DOC18/890252  
SSD 9403

**Exhibition of Residential Development - 1 & 2 Murray Rose Avenue, Sydney Olympic Park  
(SSD 9403)**

## **Attachment 1 – Office of Environment and Heritage (OEH) comments – Exhibition of Residential Development - 1 & 2 Murray Rose Avenue, Sydney Olympic Park (SSD 9403)**

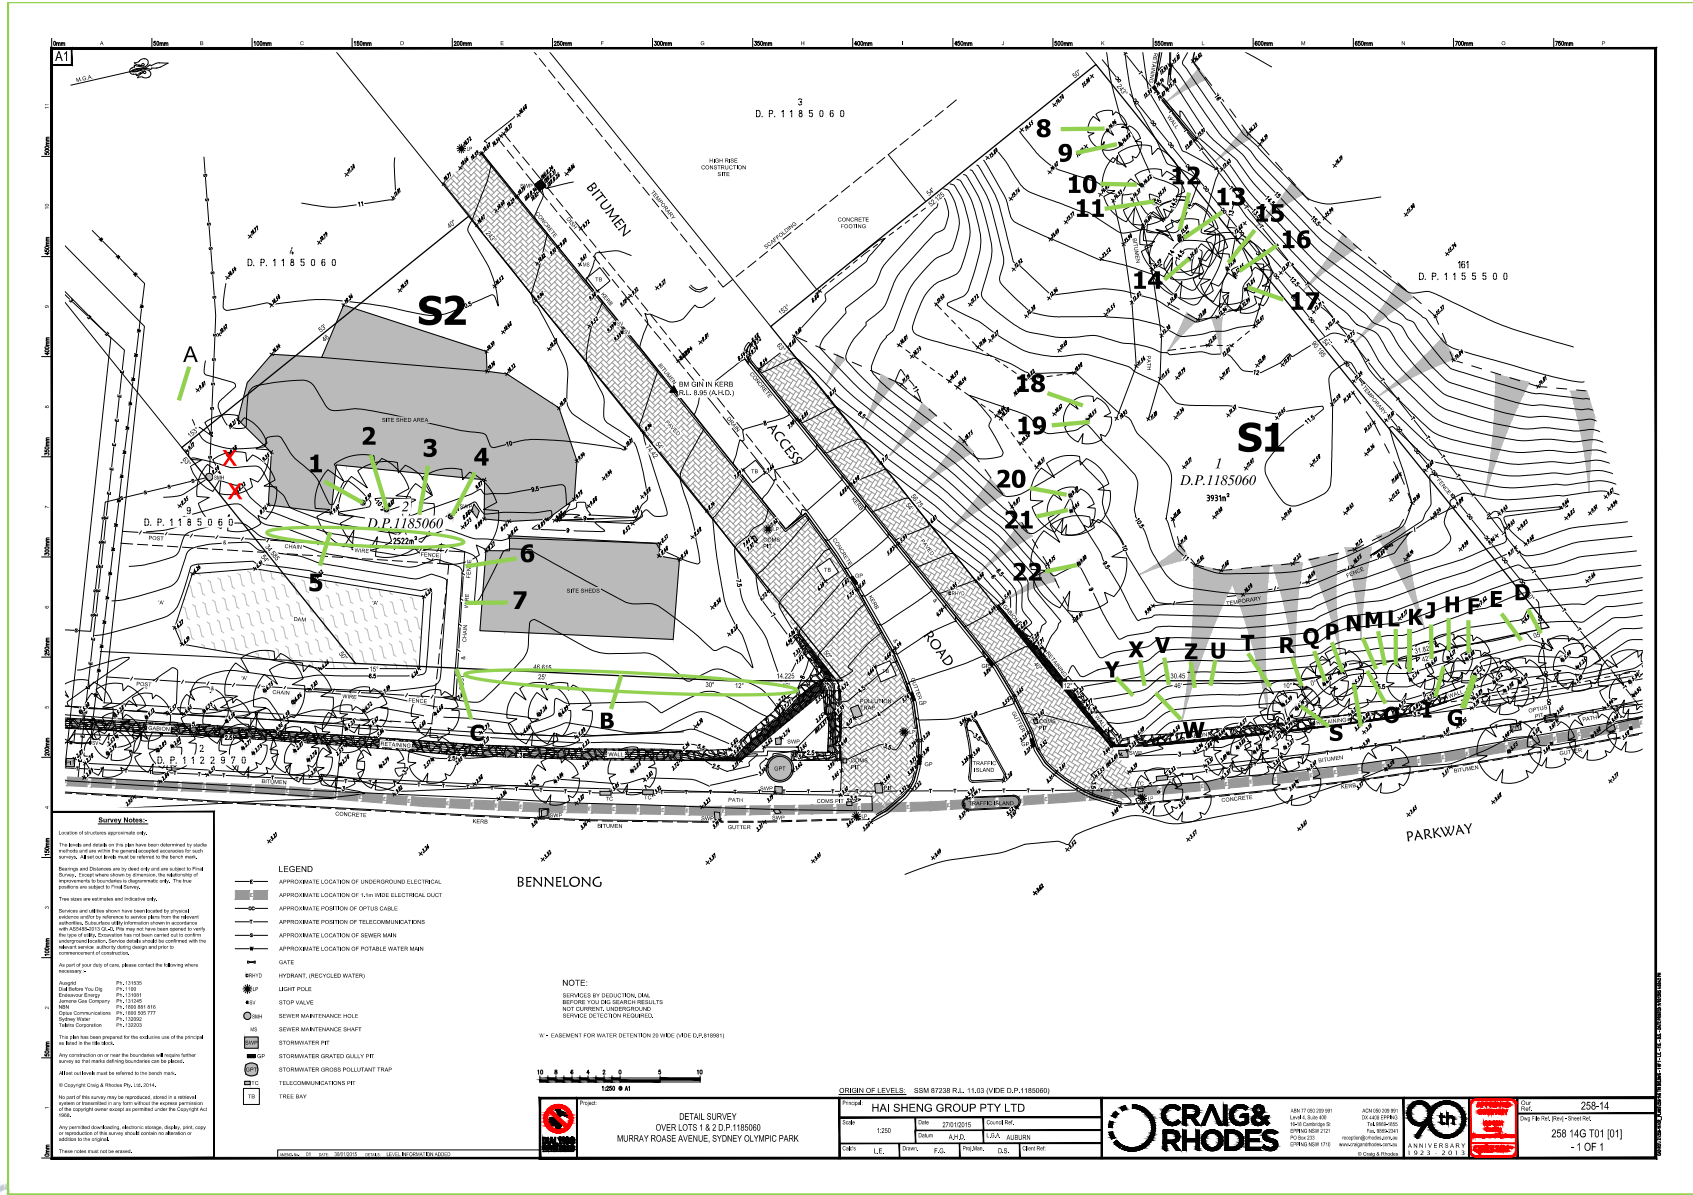
OEH also notes that the Arborist plan shows the removal of trees along the Site 1 northern perimeter boundary in particular Trees 8 and 10 (identified as being in good condition) and also Trees 9, 15 and 17 all of which are native canopy species of *Corymbia eximia* (Yellow Bloodwood) and *Eucalyptus robusta* (Swamp Mahogany) (see image below). It is unclear why these trees are proposed to be removed when given their locations along the site's perimeter could easily be retained via an adequate setback from the building footprint. This would provide amenity to new residents as they are established mature trees.

0	1	2	5	10	15m	Title	10-GENERAL ARRANGEMENT PLANS
							GENERAL ARRANGEMENT PLANS - S2 ROOF
Project PA015288						Drawing Number	Revision
1&2 MURRAY ROSE						DA-10-6400 A	
2 MURRAY ROSE AVENUE							
SYDNEY OLYMPIC PARK, NSW							
Status							
DEVELOPMENT APPLICATION

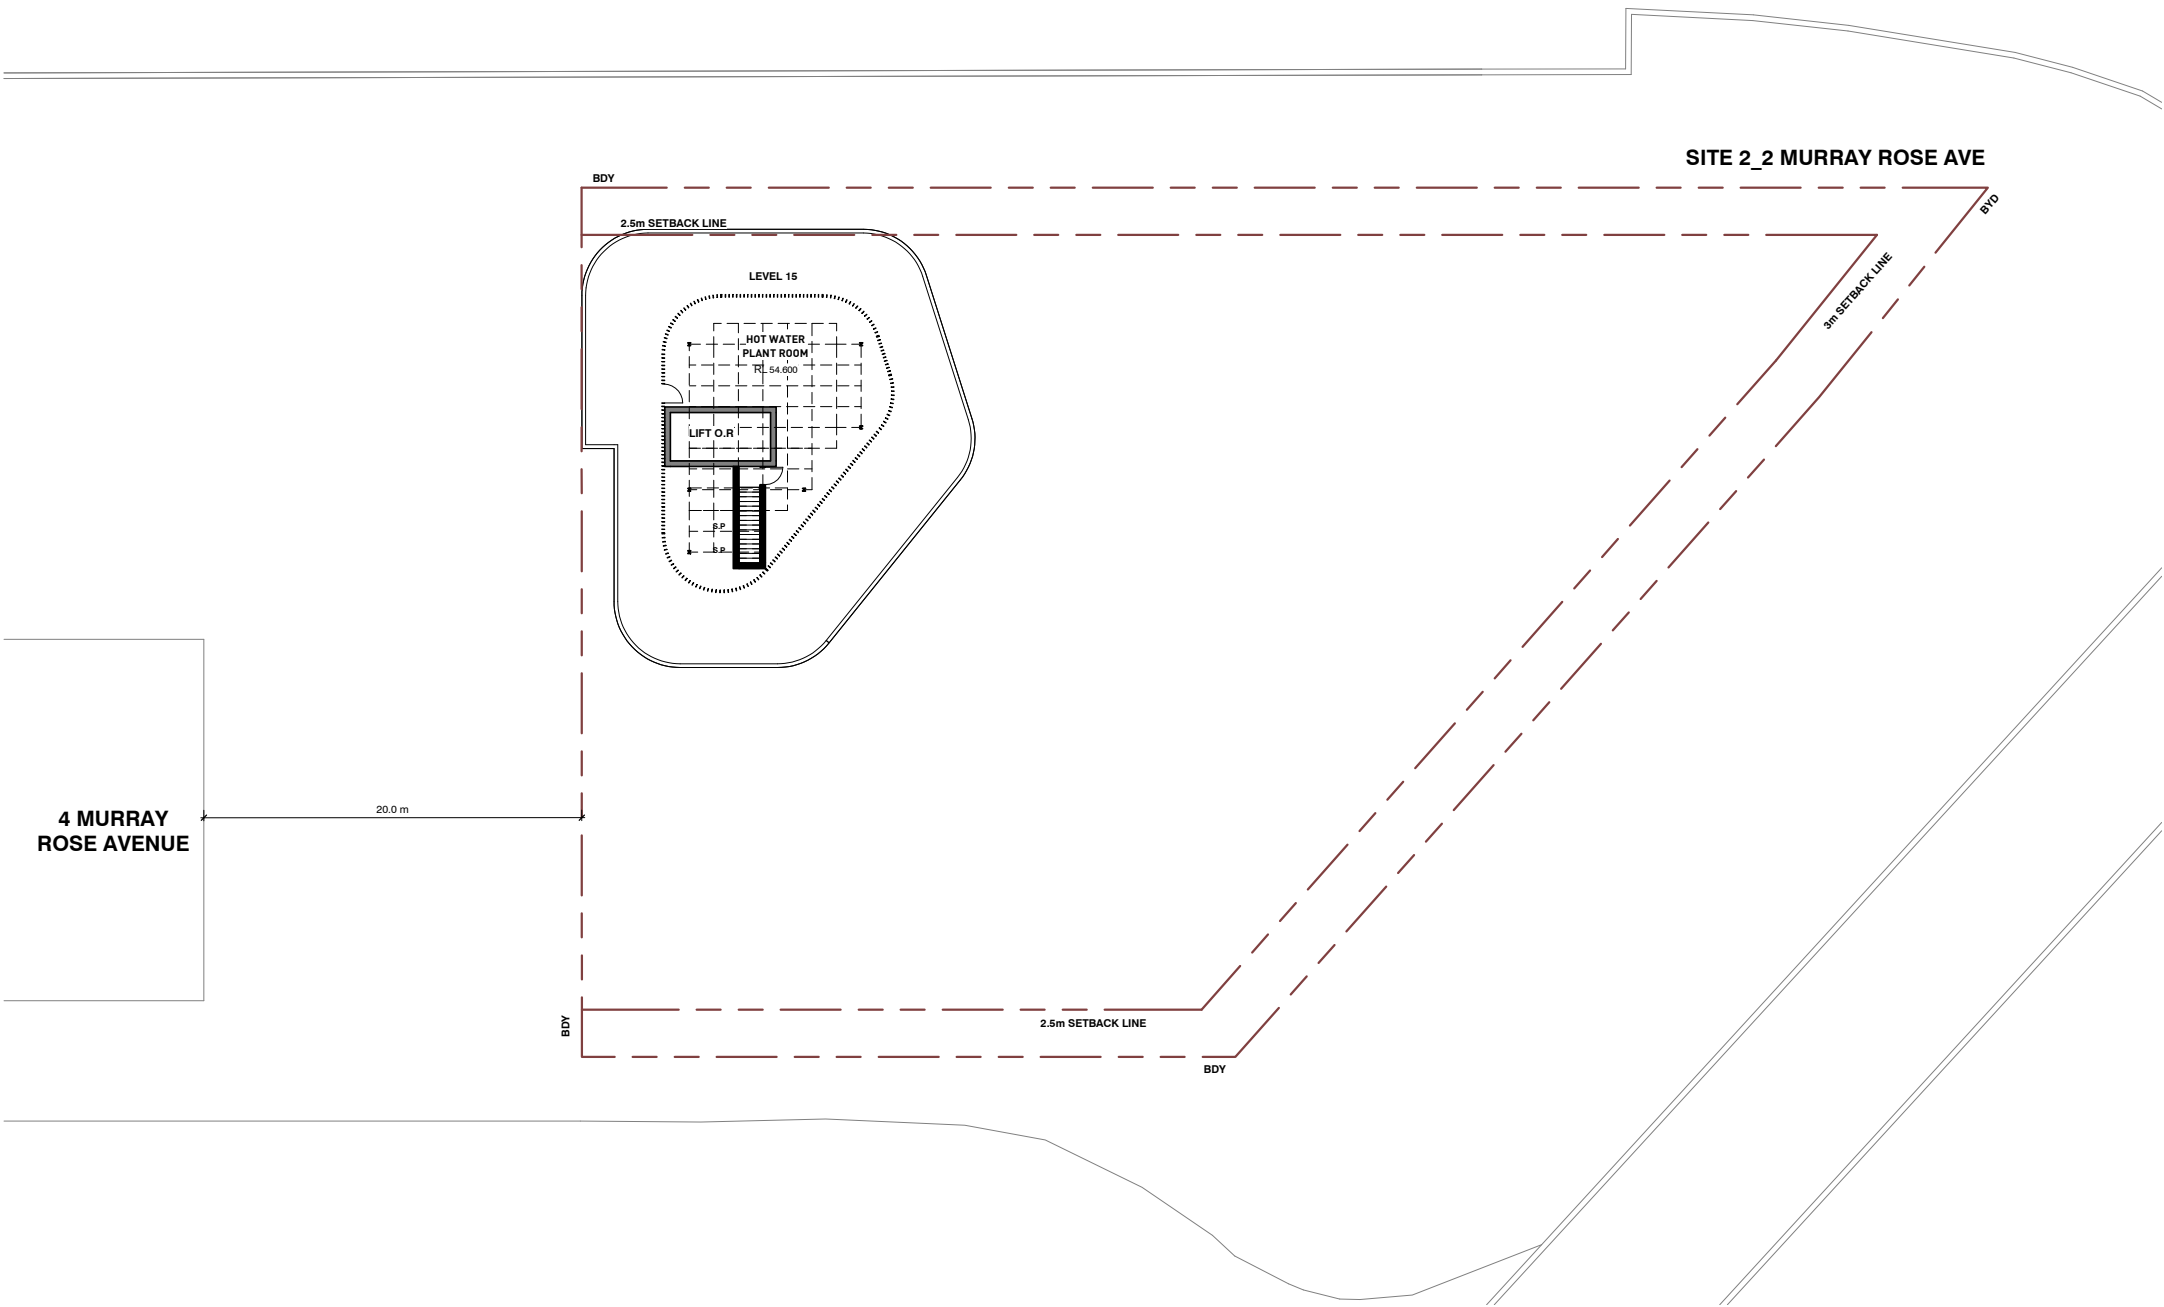
- The Roof Plan – Site 2 green roof is very limited in terms of green cover and shows extensive paved areas.
- The gabion wall as shown on landscape plan 'Indicative Illustration -Site 2 - Gabion Wall' - could be a feature green wall and also provide a better visual connection between the site and surrounding wetlands and achieve the desired landscape intent to create a 'Green Ribbon'.
